**From:** [Downes, Scott G \(DFW\)](#)  
**To:** [Kelly Bacon \(CD\)](#)  
**Cc:** [Torrey, Elizabeth M \(DFW\)](#); [Jeremy Johnston](#)  
**Subject:** RE: Notice of Application SE-20-00009 Kittitas County Ryegrass Facility  
**Date:** Thursday, December 10, 2020 1:08:16 PM

**Subject:** Notice of Application SE-20-00009 Kittitas County Ryegrass Facility

Ryegrass Application Fields

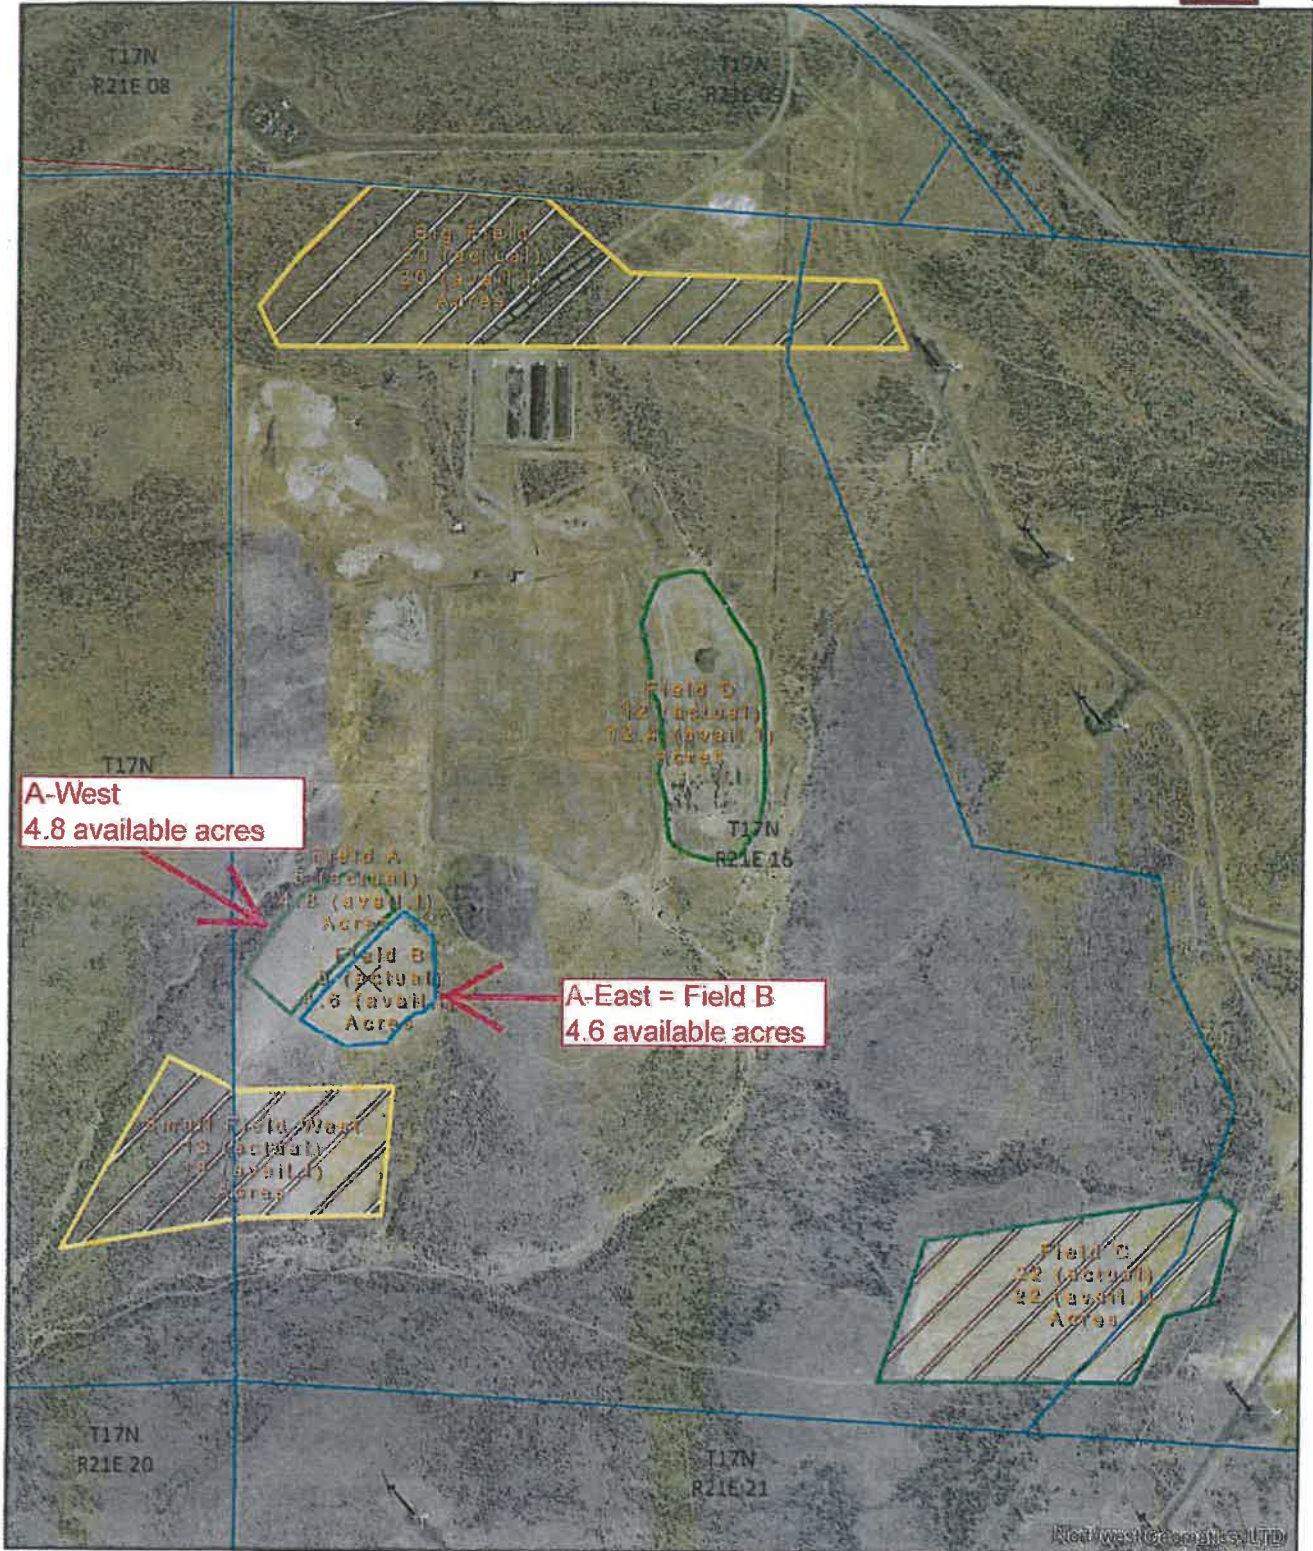
1. In between the application areas, there is sagebrush areas, which is a diminishing and priority habitat in the county. WDFW would like to see no new clearing of sagebrush in this area (so application limited to already cleared areas). If additional clearing must occur, then consulting with WDFW for mitigation to clearing would be encouraged.
2. When these fields were originally cleared, they likely contained sagebrush as evidenced by the surrounding areas containing sagebrush. When the fields are no longer desired to be used for this biosolid treatment, WDFW would recommend that sagebrush would be planted as part of a restoration plan as that would help to improve habitat in the area.
